Re: BusConnects Belfield/Blackrock to City Centre Core Bus Corridor Scheme
Co. Dublin

The Woodbine Glenomena Resident's Association (part of the wider 'Montara' forum of resident's associations) wish to make observations on the planning submission for the Belfield / Blackrock to City Centre Bus Corridor Scheme. We think the time allowed to review such a substantial, technically demanding planning submission is difficult especially at this time while schools are closed and many of our residents are on holiday. This comes on the back of an earlier proposal to extend the cycle track from Booterstown Dart station and other changes to reduce the Trimleston Avenue to a single lane at the Rock Road junction. However, we have the following observations to make:

Seafield Resident's Association, part of the wider 'Montara' forum of residents' associations, wishes to make observations on the proposed Belfield /Blackrock to City Centre Core Bus Corridor Scheme.

BusConnects Dublin - Belfield / Blackrock to City Centre

Programme Title: <b>BUSCONNECTS DUBLIN CORE BUS CORRIDORS INFRASTRUCTURE WORKS</b>			
Drawing Title: BELFIELD / BLACKROCK TO CITY CENTRE CORE BUS CORRIDOR SCHEME GENERAL ARRANGEMENT			
Drawing File Name: BCIDC-ARP-GEO_GA-1415_XX_00-DR-CR-0010	Sheet Number: 10 of 24	Status: A	Rev: M01

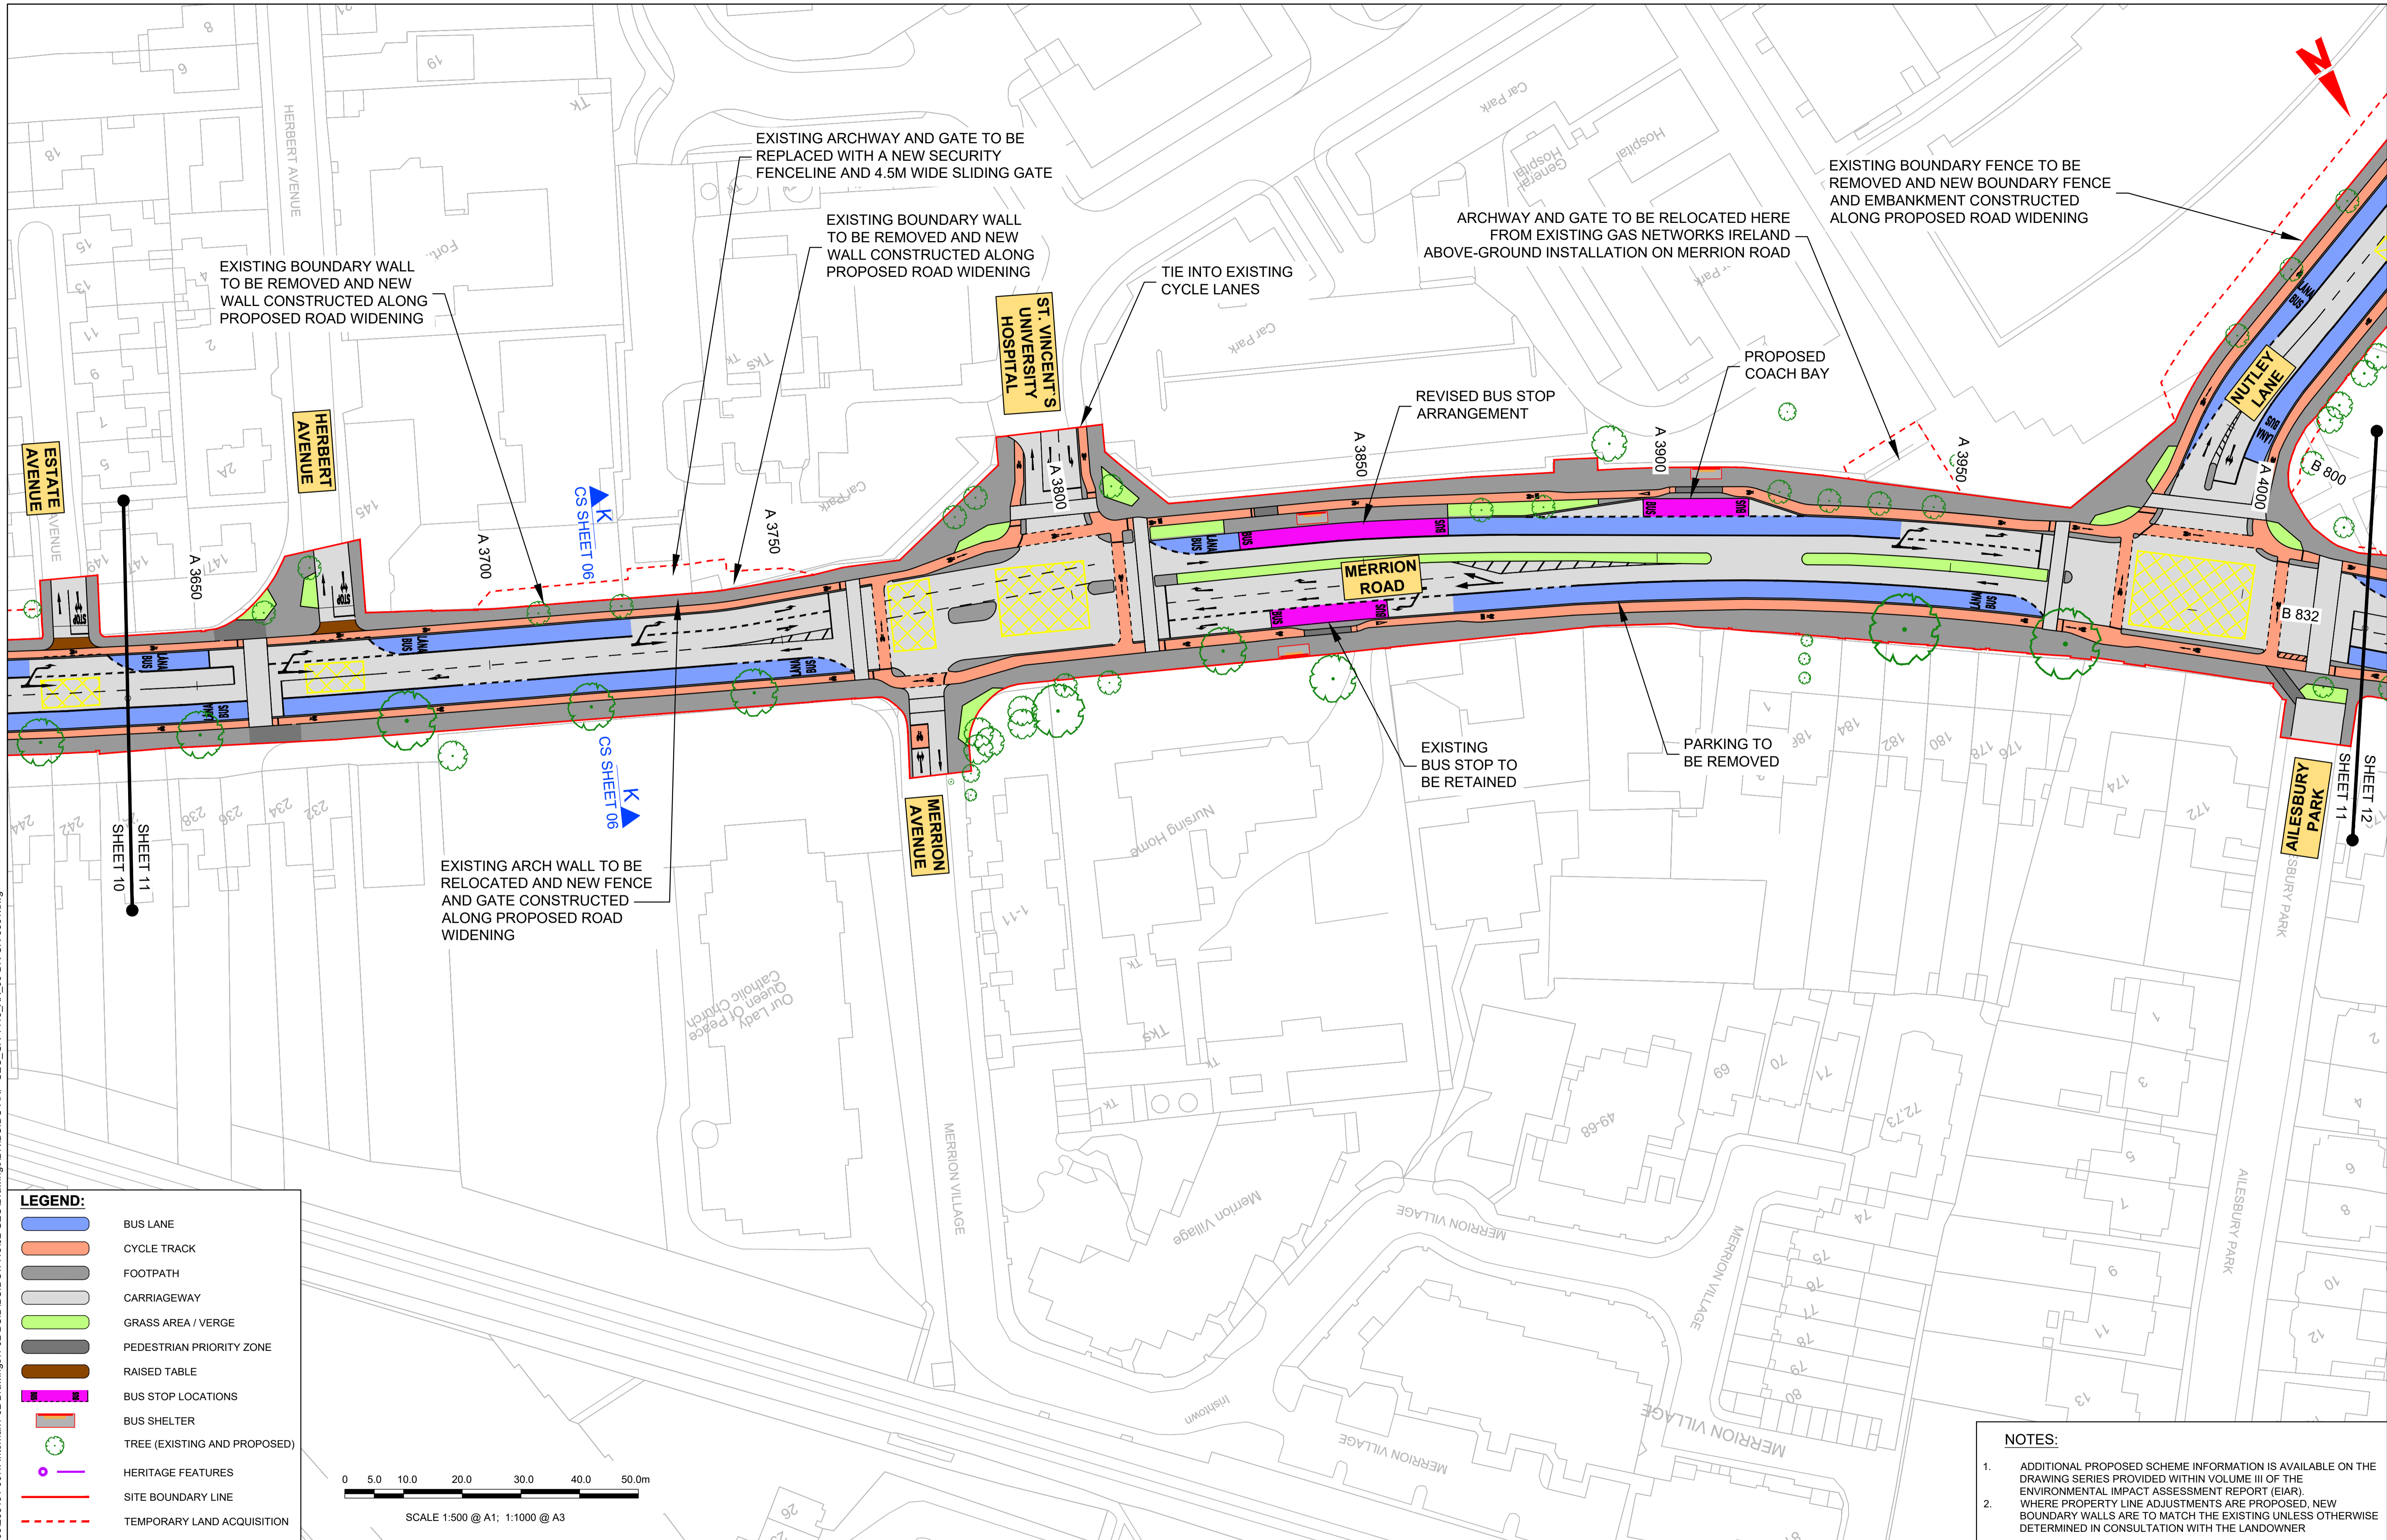
c) In sheet 9 and 10, we are concerned regarding the suggested removal of TWO HISTORIC arches on the Merrion Road. It is not clearly mentioned in your Environmental Impact Assessment Report that both these arches are in fact historic and protected structures.

We are concerned that the plans are suggested to potentially move these arches further down the street. From our review the Historic Entrance Arches are protected.

a. Our proposal: is for these arches to remain as stands in their rightful place along with the Merrion Castle, which date of construction is going back to the 15th century.

b. Resident concerns: We are concerned that such protected Architectural and historical, structures are being moved and potentially could be damaged in the process of the proposal.
